September 9, 2021

**Re: Summary of Modifications to Meet EPC Conditions of Approval  
Albuquerque Studios Expansion  
Amendment to the Mesa del Sol Level B Plan**

This letter outlines the modifications that have been made to the Mesa del Sol Level B Amendment application to amend their site development plan (PR-2021-005684) to meet the conditions of approval outlined in the Notice of Decision issued on August 19, 2021.

Table 1-1 Development Program

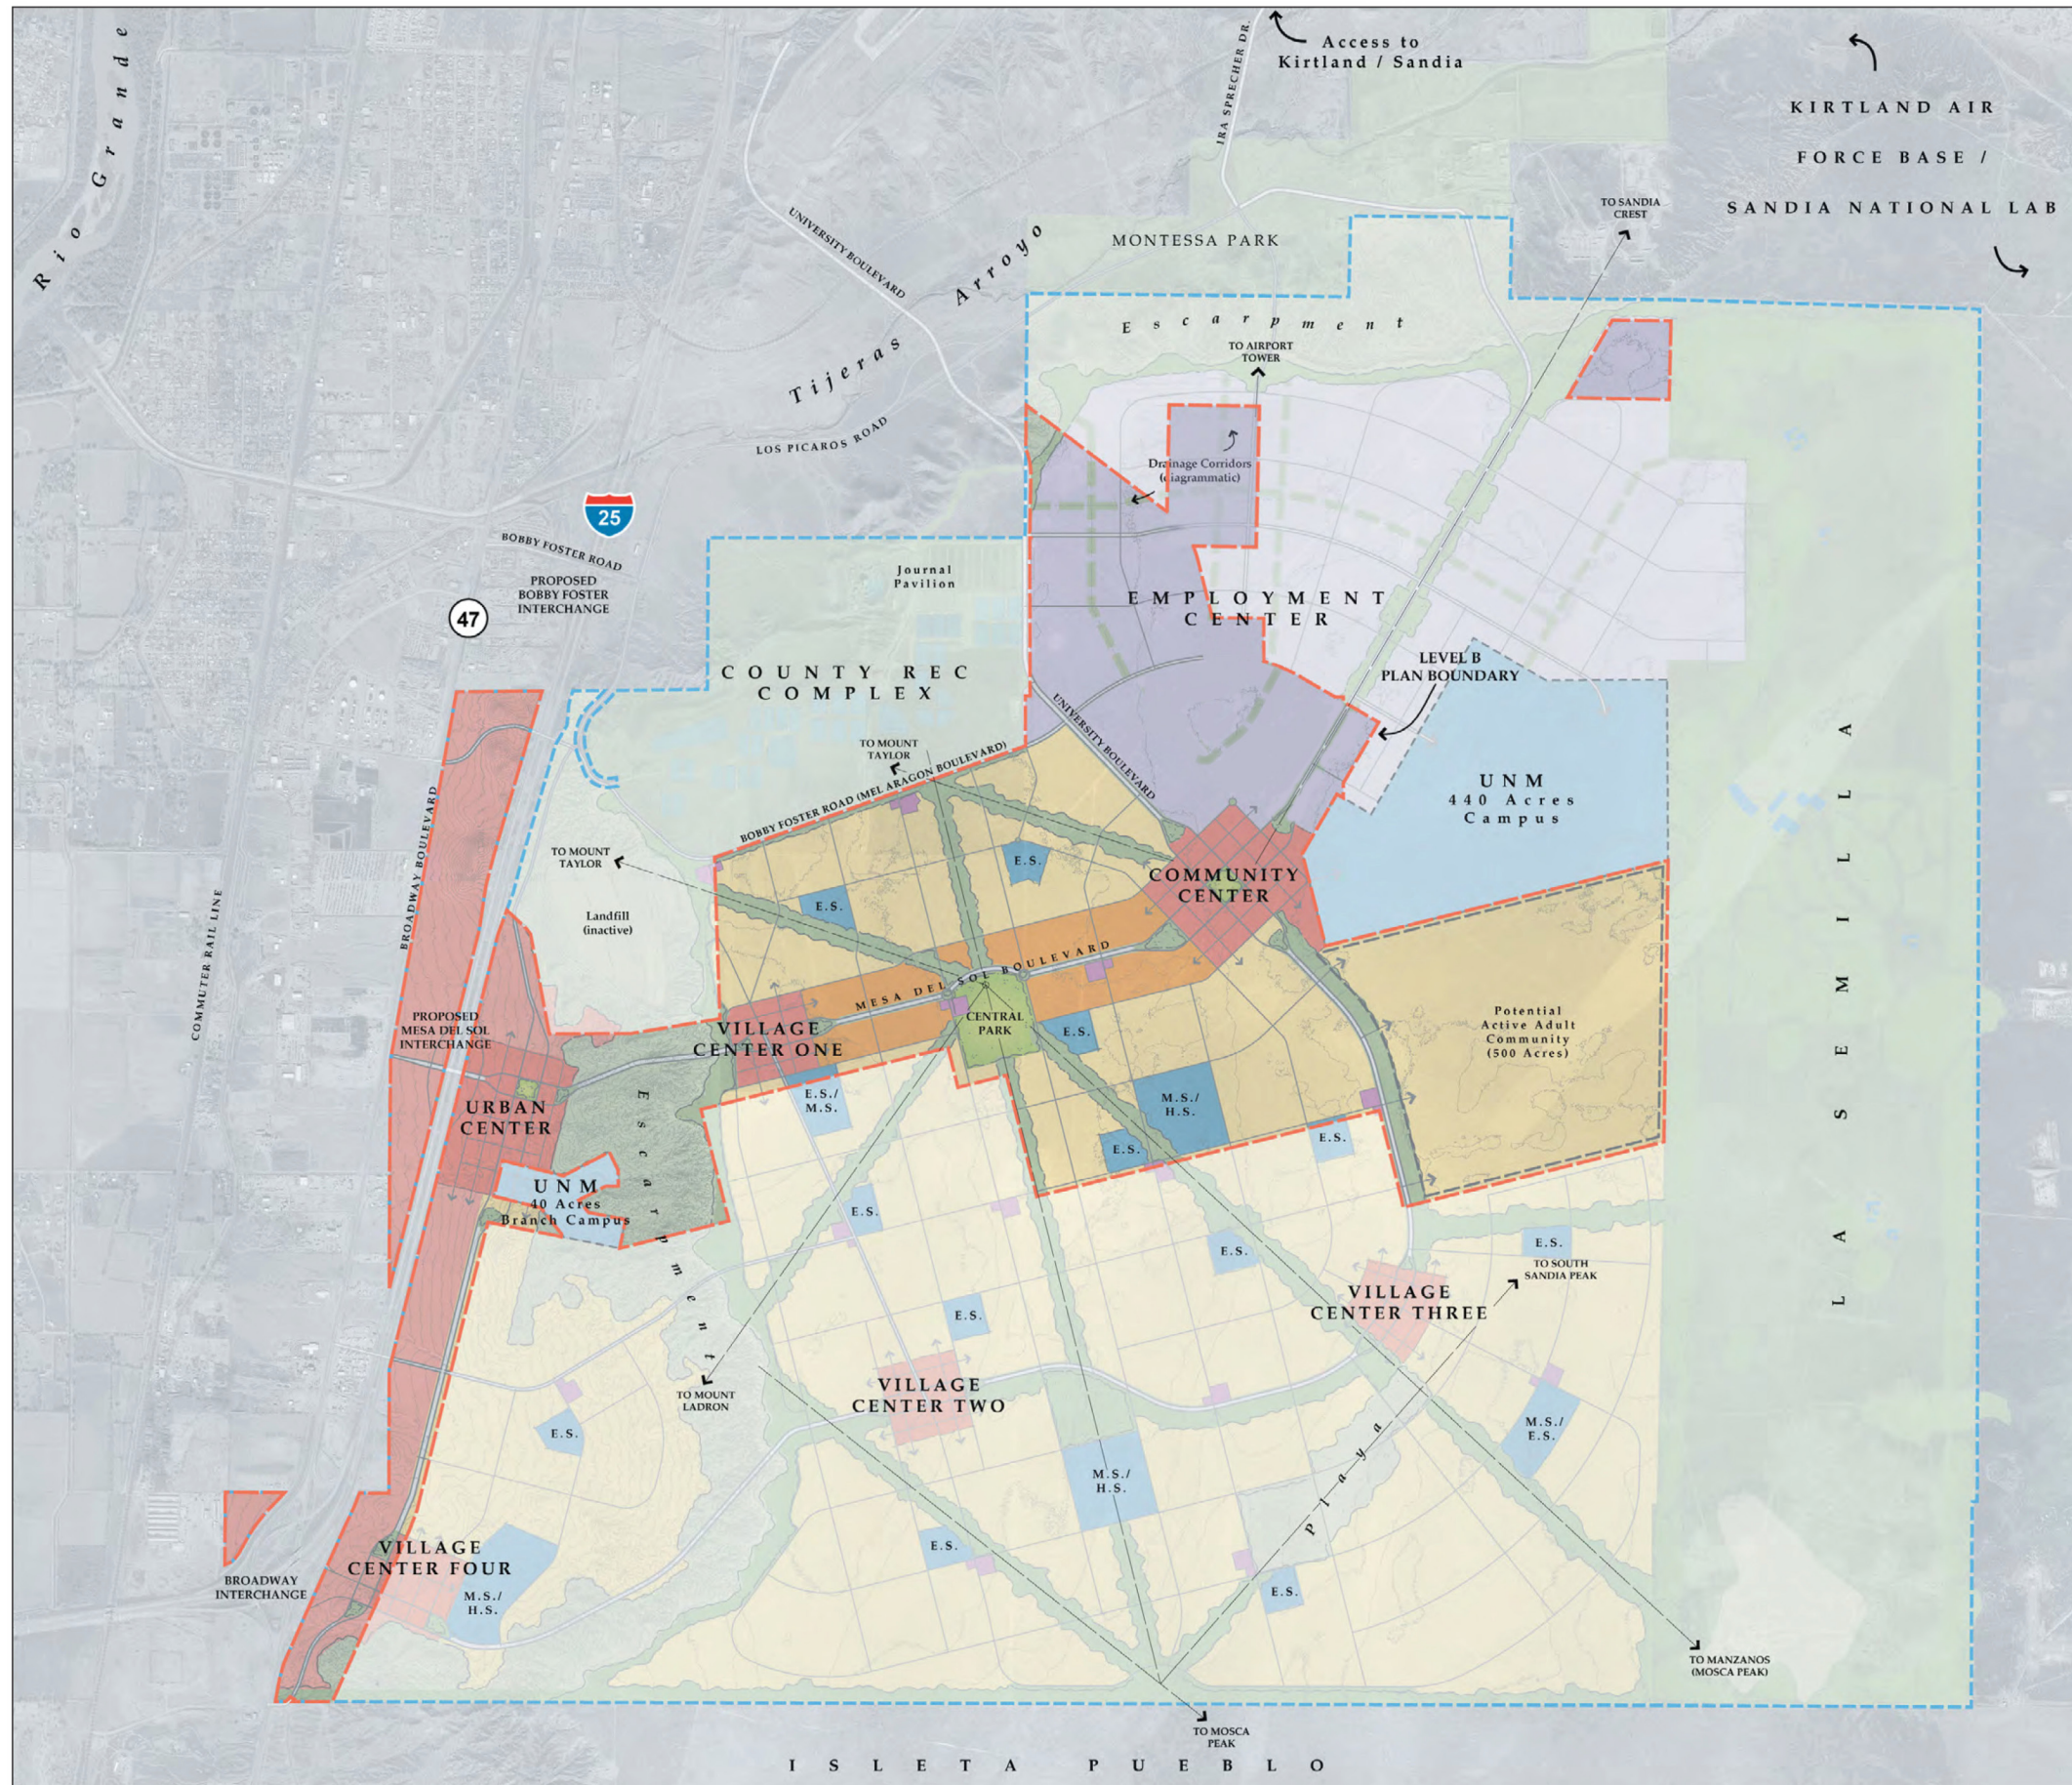
**The figure for Total Area shall be updated to reflect the reallocation of 36 acres from Linear Open Space to Employment Center.**

The applicant has revised Table 1-1 Development Program to reallocate the 36 acres from Linear Open Space to Employment Center. The original acreage of Linear Open Space decreased from 173 to 137 acres and the acreage allocated to the Employment Center increased from 626 to 662 acres. The subtotal for the development area therefore increased to 2,789 acres from the original 2753. The total area of 3151 remains the same as the 36 acres reallocation was already included in this number.

LEVEL B OVERALL PHASING PLAN

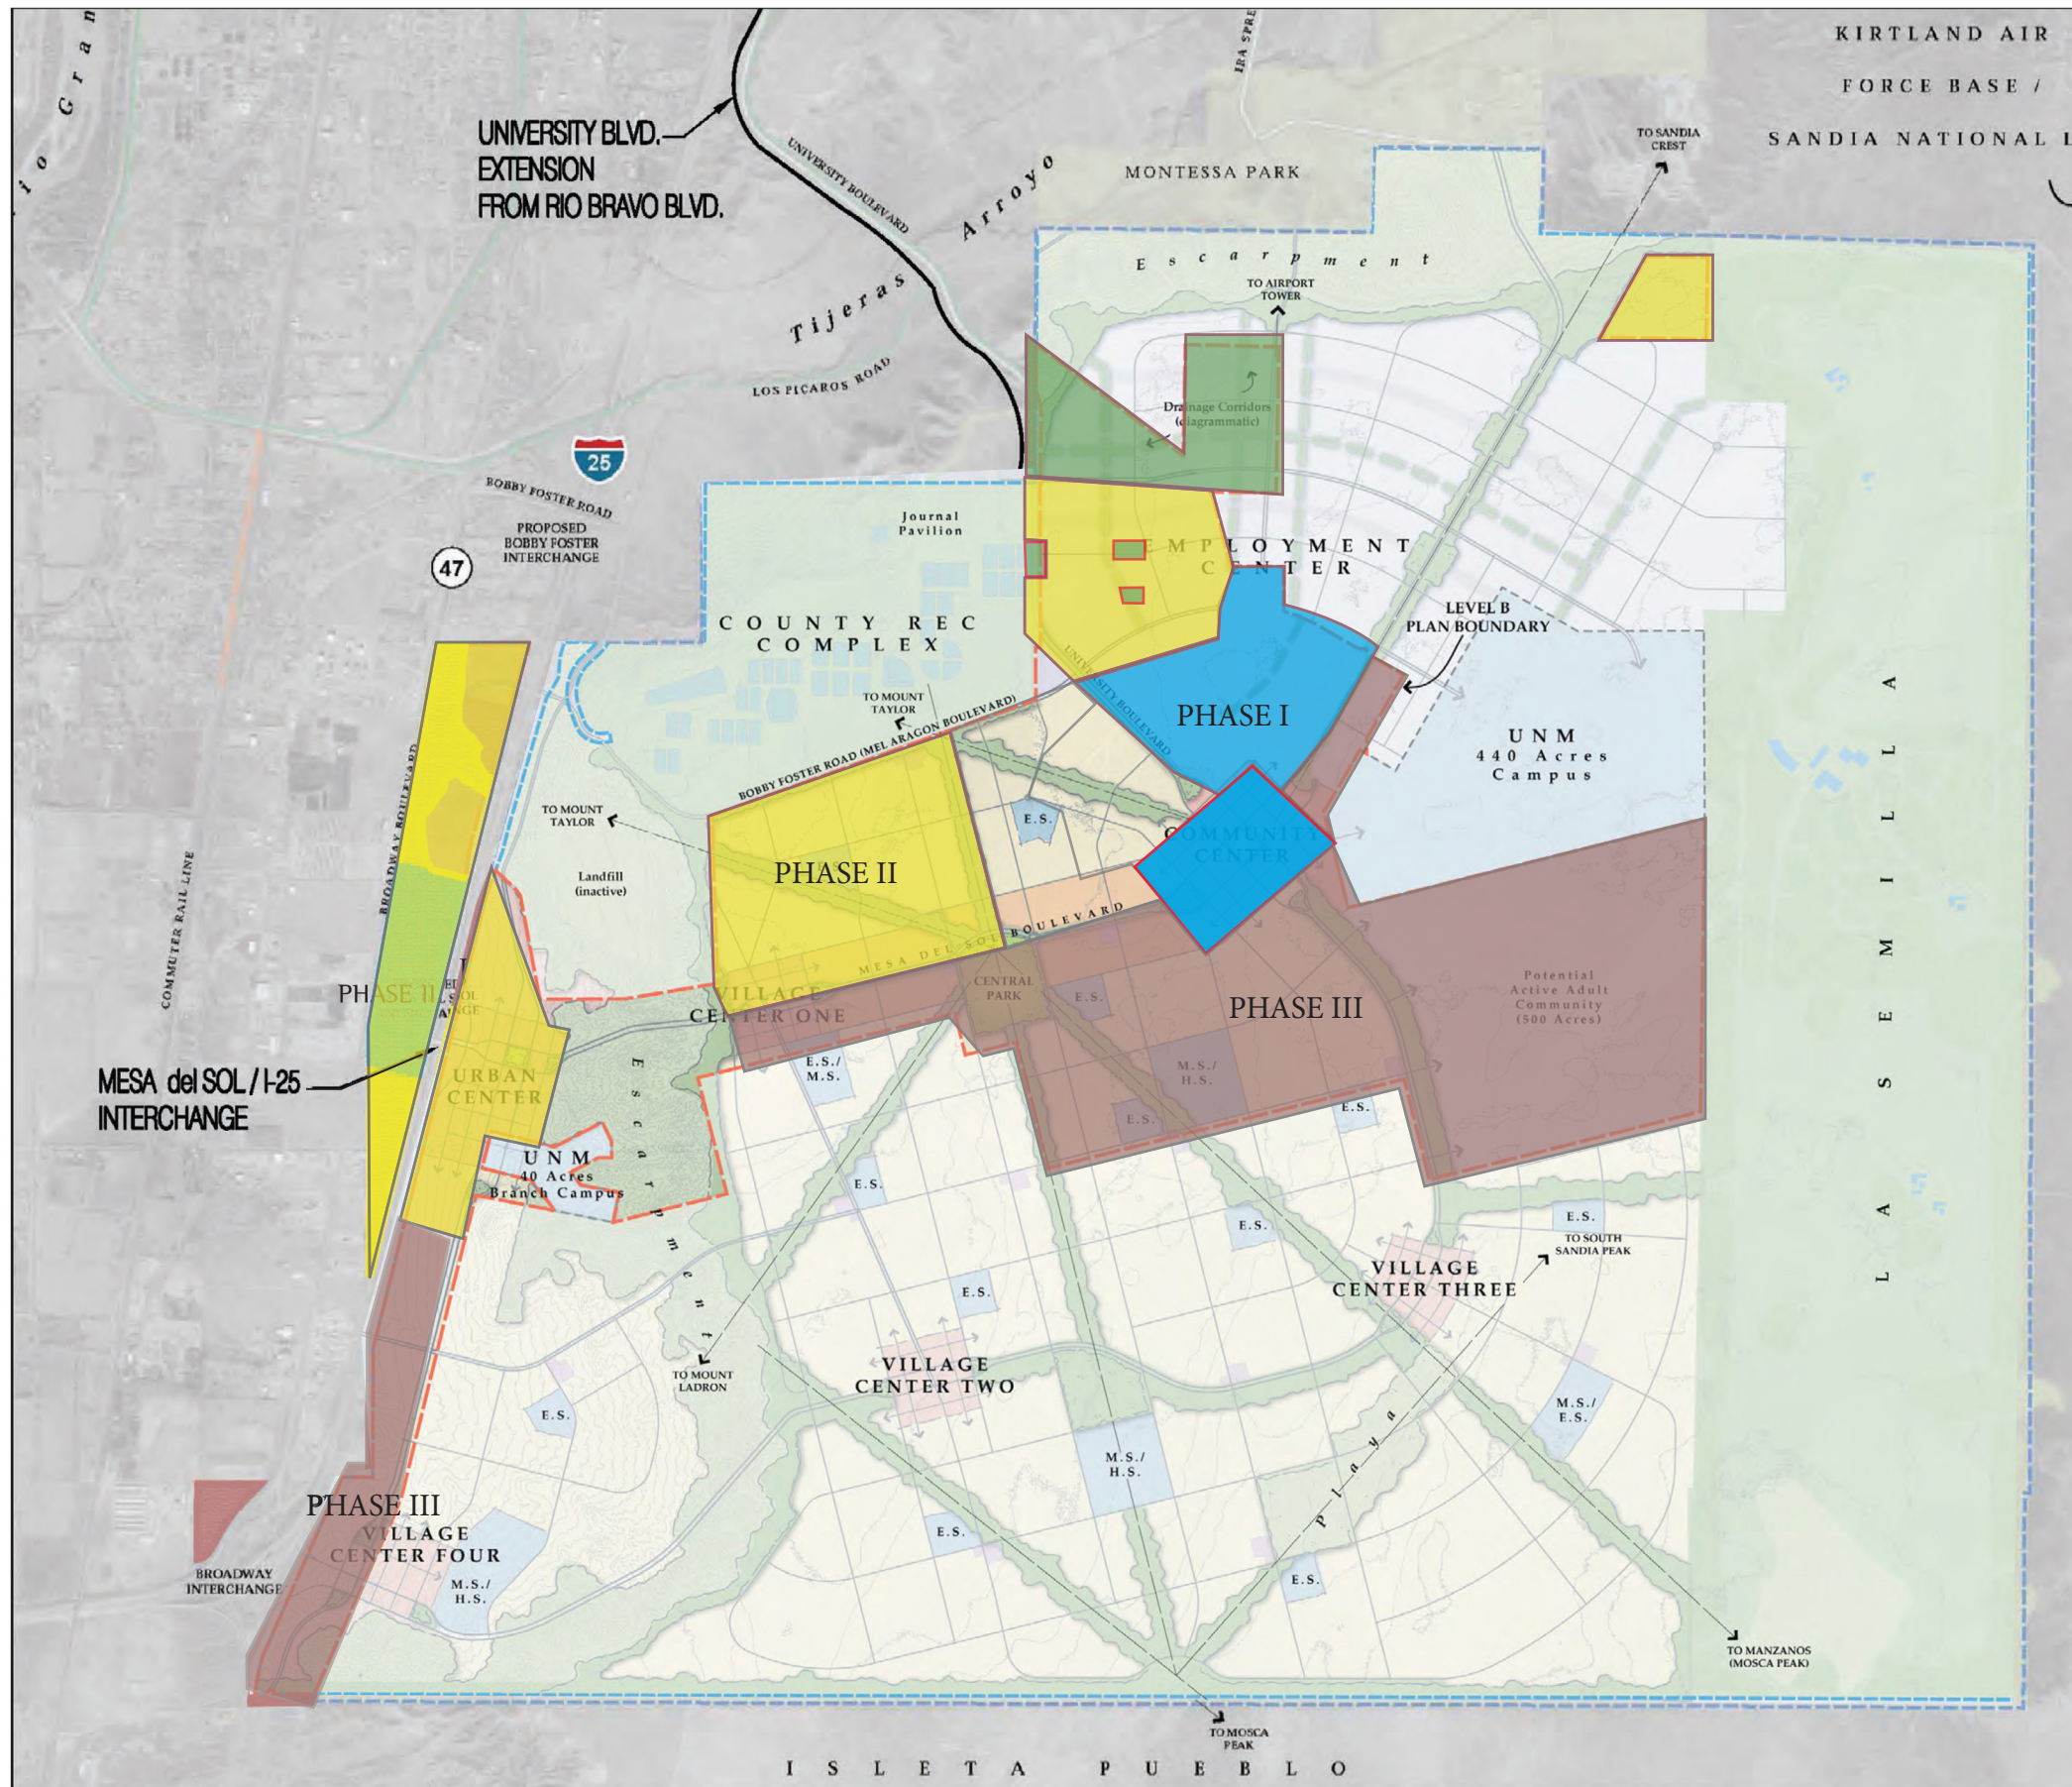
- A. Figure 2-3: Reference shall be changed to p. 42 and the proposed change map “pending” shall be provided.**
- B. Figure 3-1: The grid of local roads (orange) shall continue to be shown in the background.**

The applicant has updated Figure 2-3 to reflect updates to the proposed phasing. In addition, Figure 3-1 has also been revised to include the grid of local roads that exist outside of the subject site.
